RE: Cloverleaf TIS Response to Comments

Kellar Engineering (KE) comment responses in **blue** font.

Figure 3: Recent Peak Hour Traffic

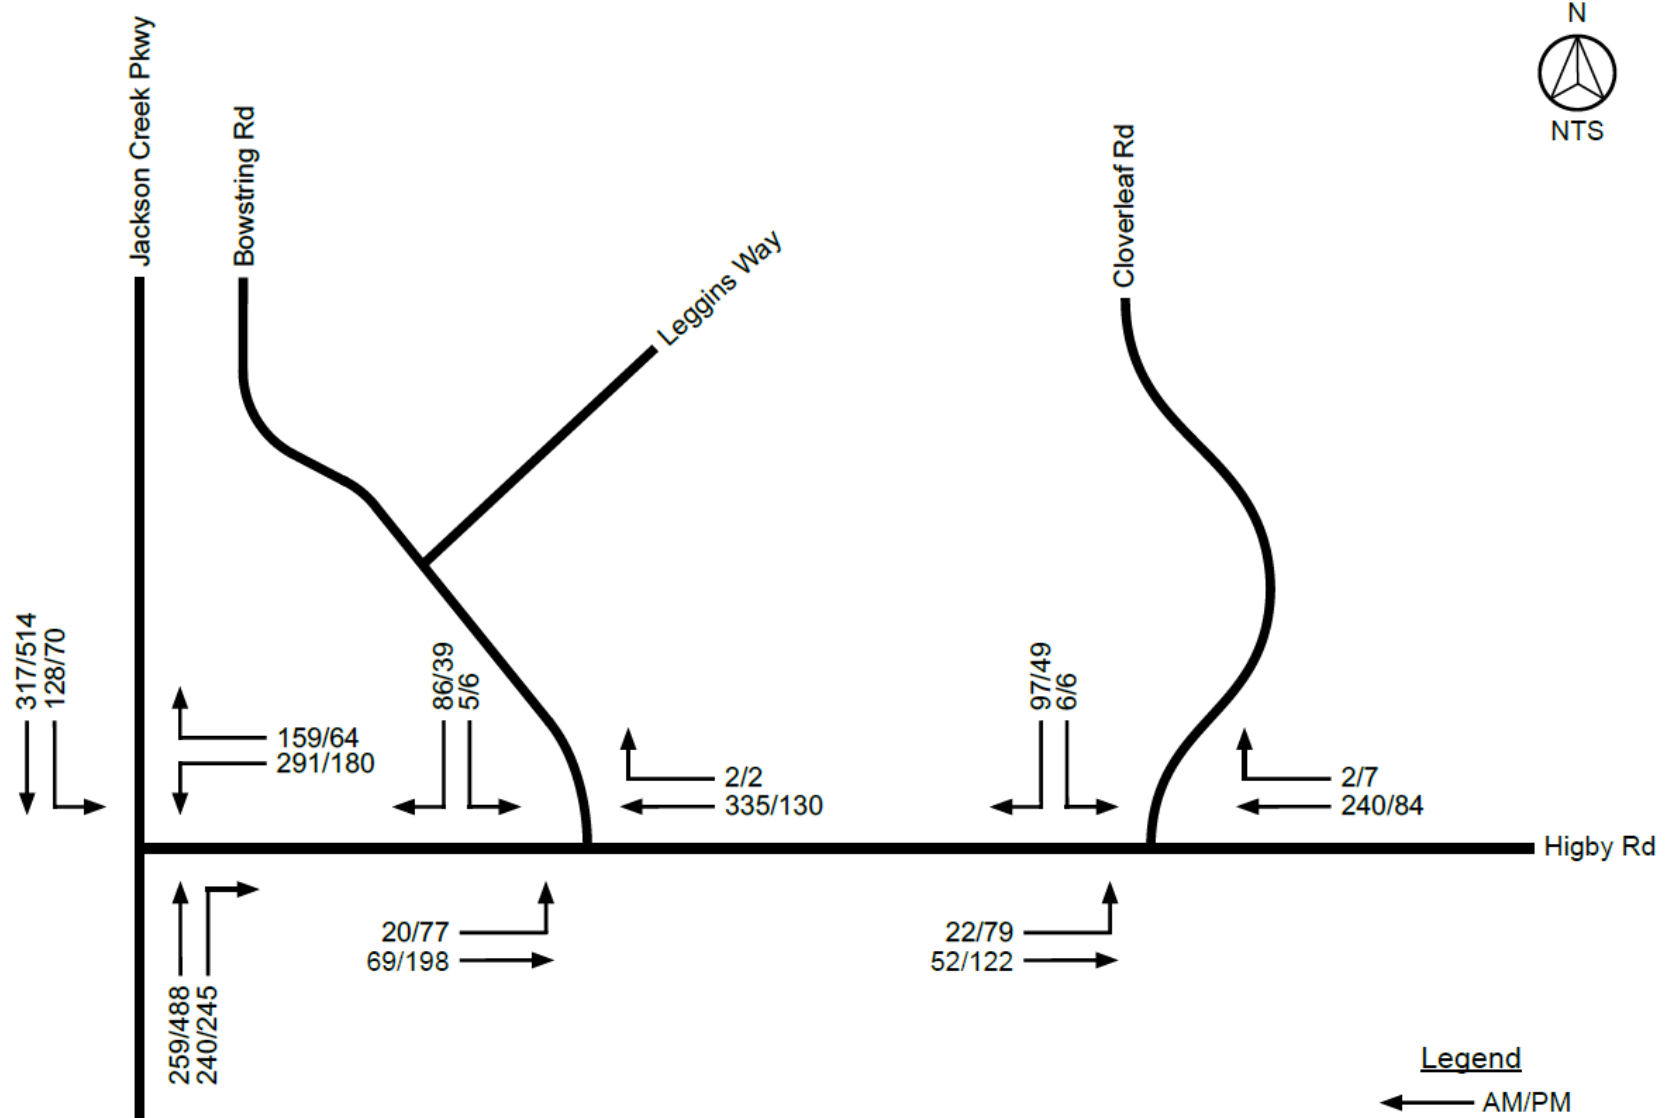
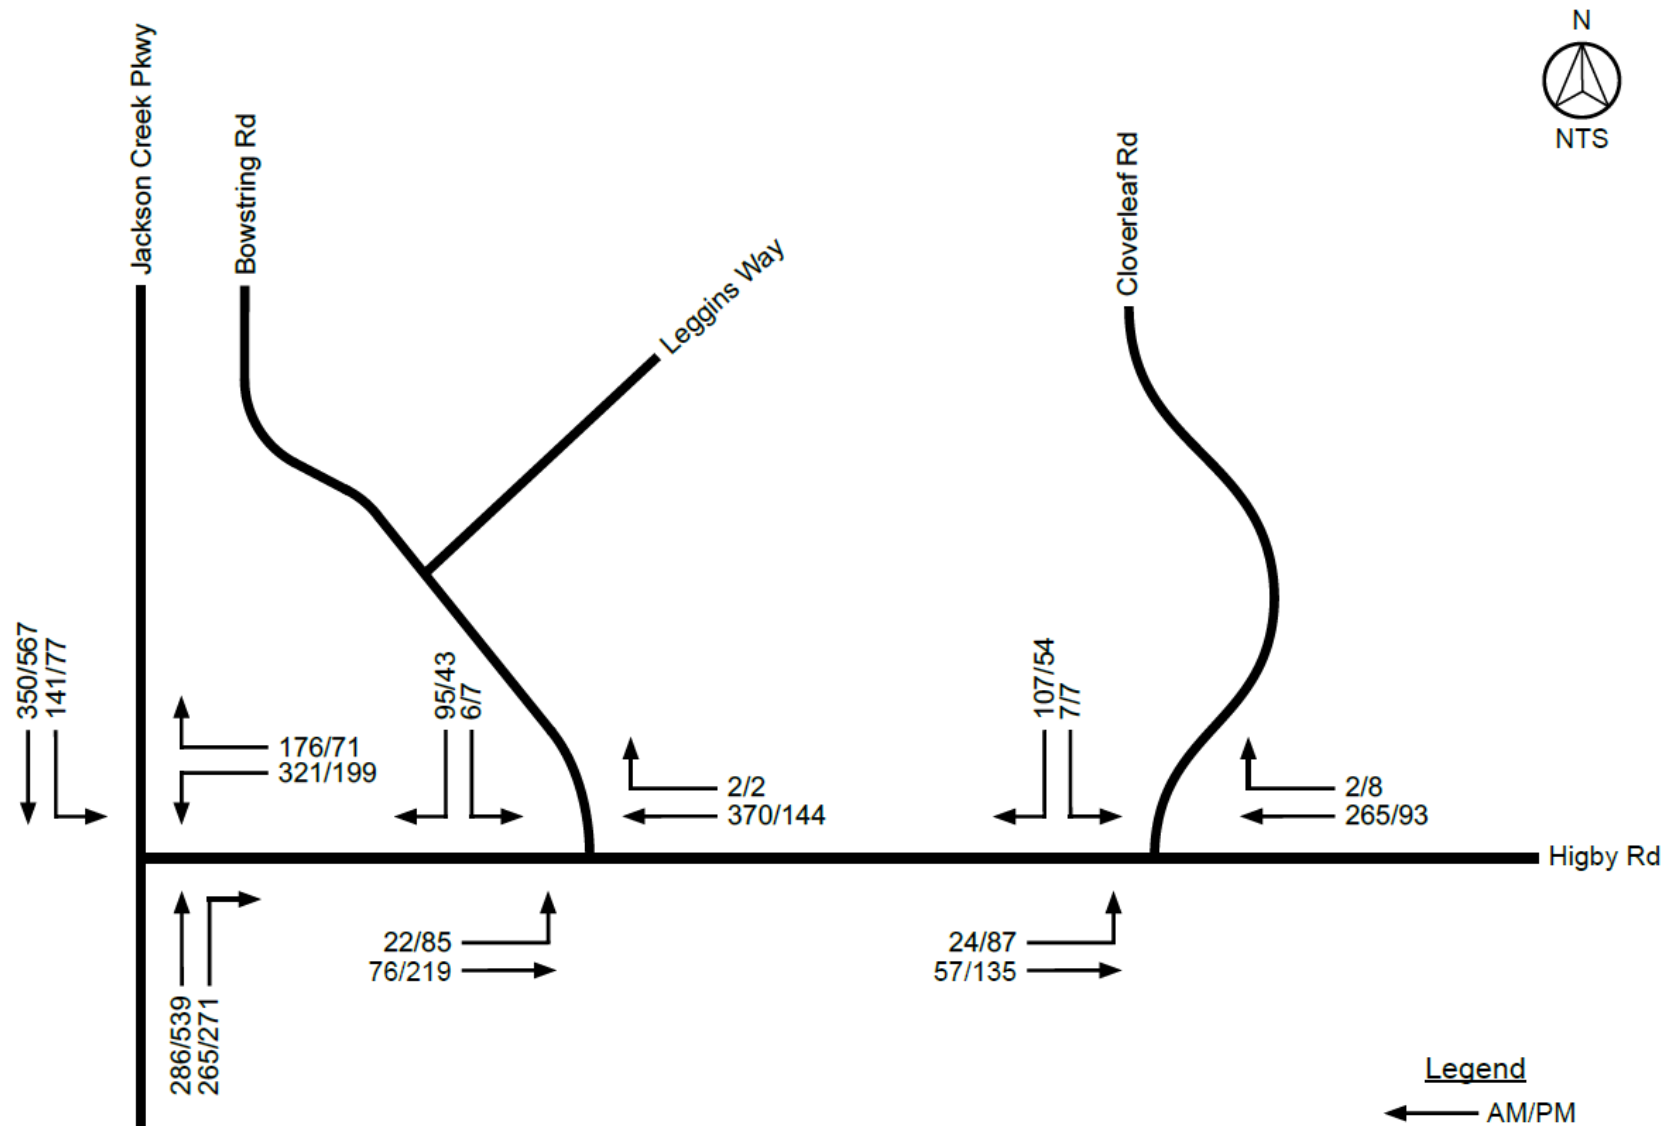
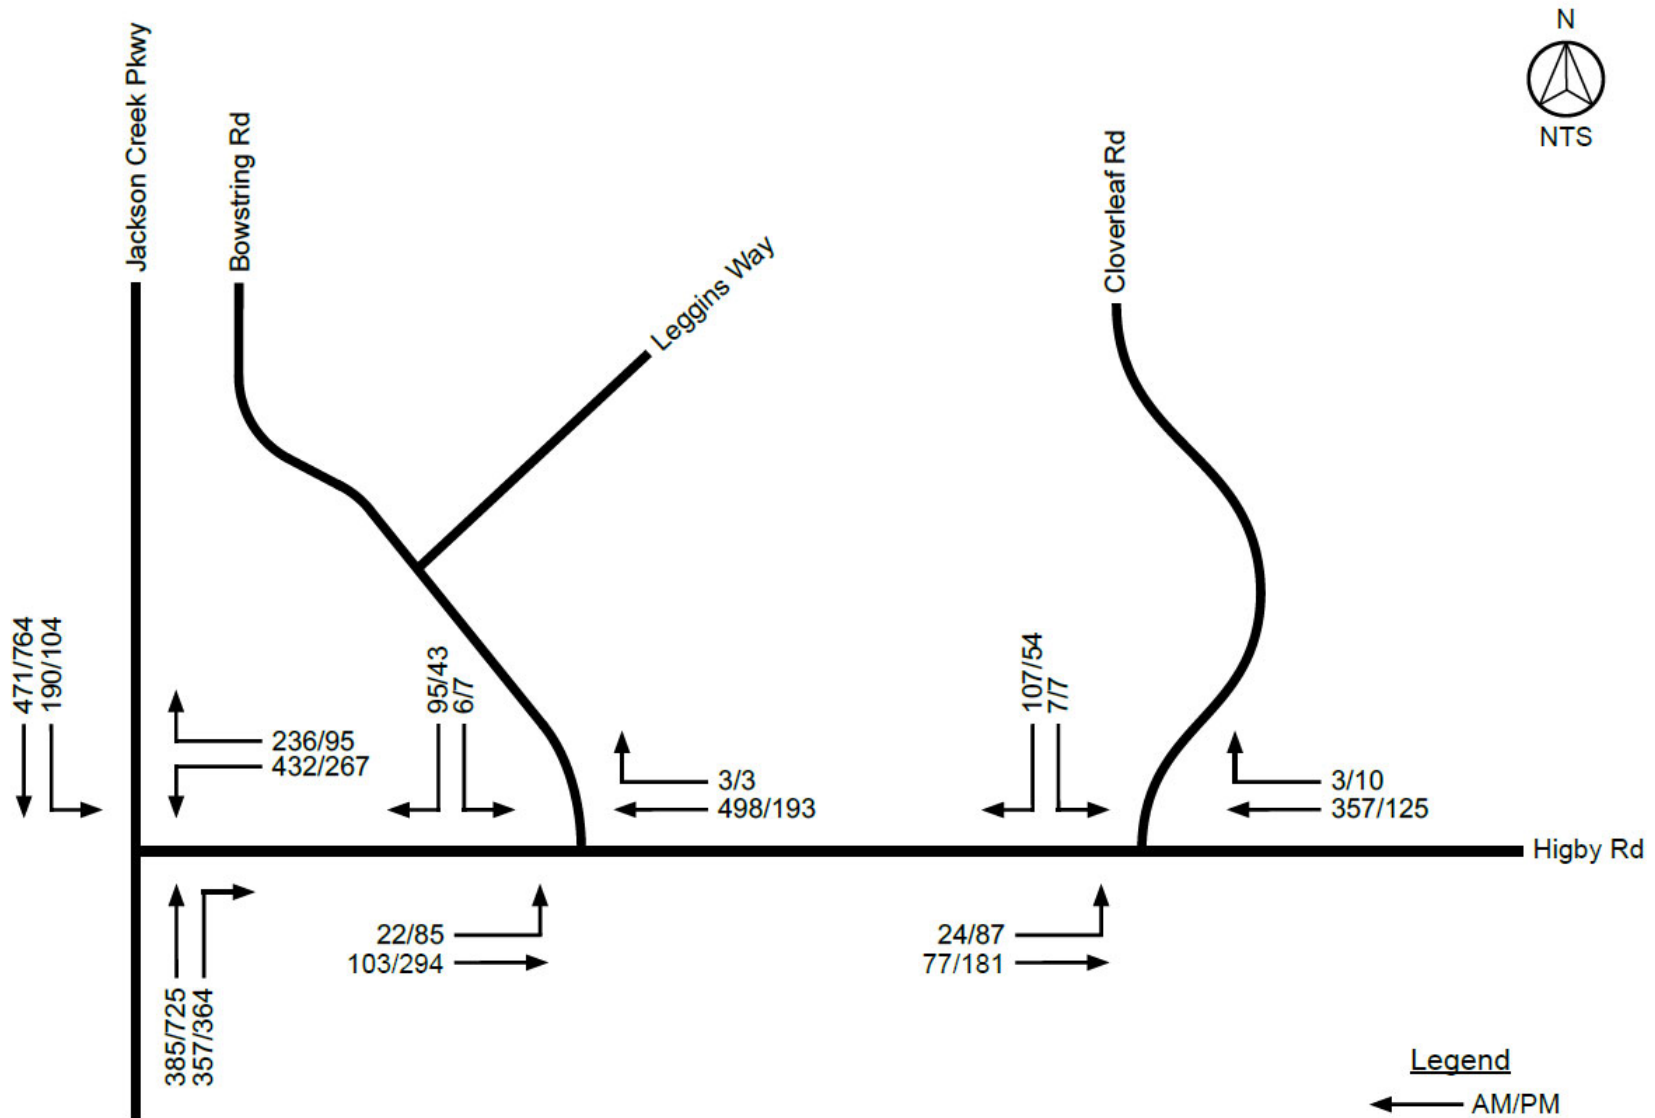
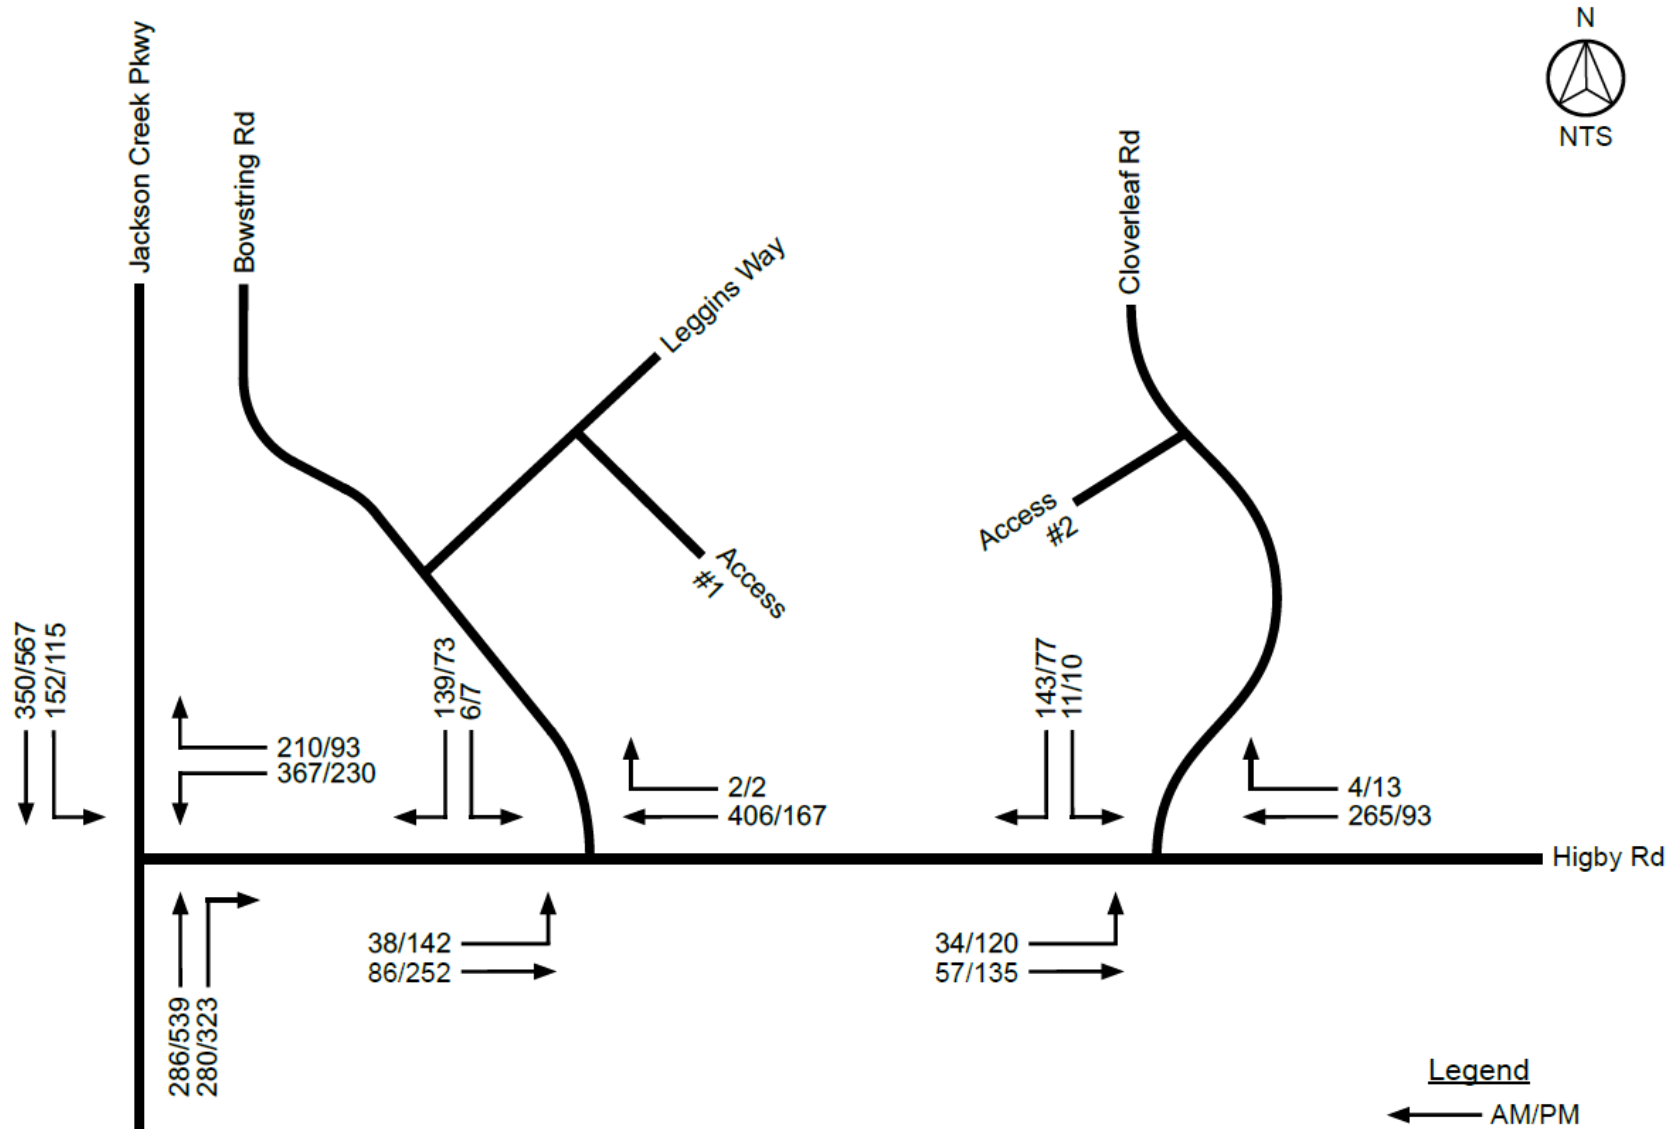
2. Comment. Update Figures 3, 4, 5, 8, and 9 to include Walters Point.

5. Comment. Add Walters Point in the TIS analysis. The applicant submitted a deviation request classifying Walters Point as Urban Local Low Volume with approximately 450 ADT with no supporting traffic analysis for the value stated.

Response. Figures updated accordingly.

Response. The ITE Trip Generation Manual was used to calculate the existing ADT on Walters Point. The average trip rates for the land use on Walters Point was used to approximate the traffic on Walters Point. Figures 3, 4, 5, 8, and 9 have been updated accordingly.
